Planning condition 12

LBH responses

| Project | LON4 |
| Date Issued | 11/12/2024 |

Drawing Title: Building 1 - South Elevation	
Drawing Type: General Arrangement	
Project Status: STAGE 4B ISSUE	
Discipline: ARCHITECTURE	
Status Code: S4	
Scale @ A0: 1:100	
Revision: P05

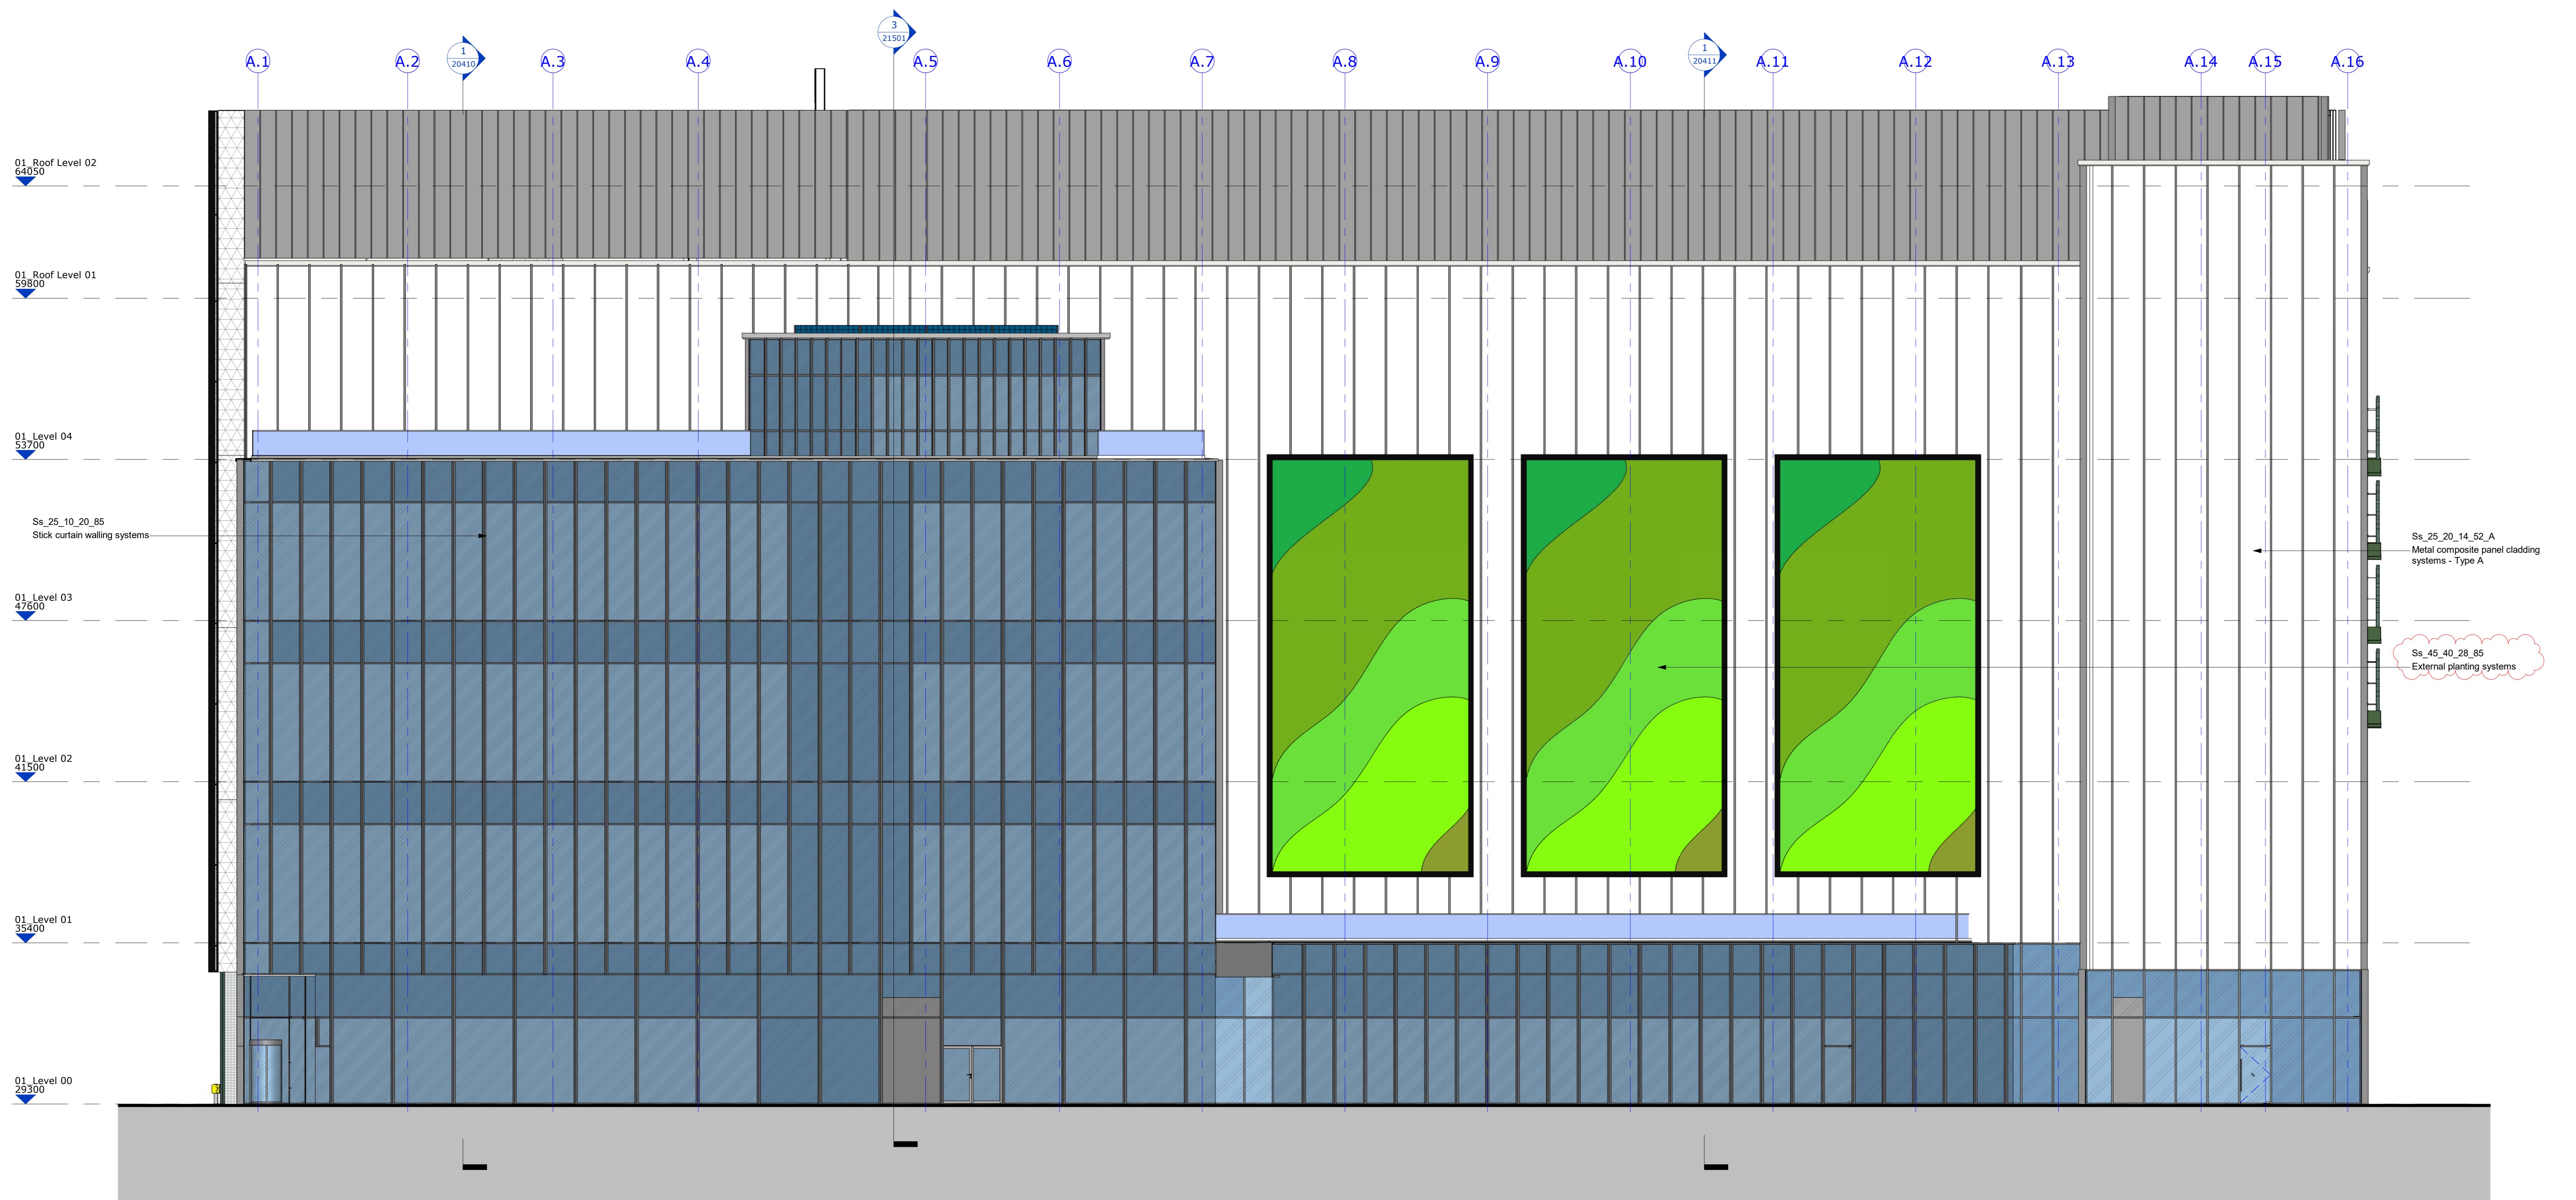
- The rich variety of plant species on to the southern green wall is welcomed.
- The chosen mobilane panel on the South Façade doesn't allow for root growth as pockets aren't interconnected.
- The chosen mobilane panel on the South Façade and associated elements such as the cassettes, pixels and cover are made of Expanded Polypropylene, which is combustible.

Proposing combustible material on the external façades of tall buildings is problematic, no matter if few or many people occupy the building. We understand that there is a slight difference between residential and industrial uses however this building is occupied day and night and combustible materials unnecessarily compromise fire safety. The design team should consider lesson's learned from Grenfell's tragedy and Building Control officers input must be sought. Measures should be taken to adequately remove, reduce, or prevent the participation of combustible components within the Living Wall system. The wall should be predominantly non-combustible apart from organic matter especially if it is that tall.

Irrigation / Drainage pipework should be discrete, non-combustible and vertically run within the shadow of vertical fins and horizontally behind the planter. Please confirm colour/materiality of pipework.

Based on the comments above we conclude that the southern green wall system is of substandard due to its combustible materiality and due to the fact that it prevents flexible root growth. Considering siting and sizing of the southern green wall this is of great concern.

The Hedera system that we are proposing to use is designed as fire retardant polypropylene. See extract from Hedera fire testing report for the green wall used on LON4 (report is not in public domain, carried out by Efectis – R000817).

South elevation – MobiPanel FR test document reference number **2021-Efectis-R000817** defines the reaction to fire classification with the procedures described in BS EN 13501-1:2018 is given a classification of **B-s2, d0**.

With regards to the root growth, we have been advised by the supplier that the cassettes allow the roots to grow and expand through the cassette as it is porous, towards the back panel which has additional space for root growth. The maintenance strategy has been designed to avoid any plant failure, together with the irrigation system we do not expect the green wall to have any failure risks.
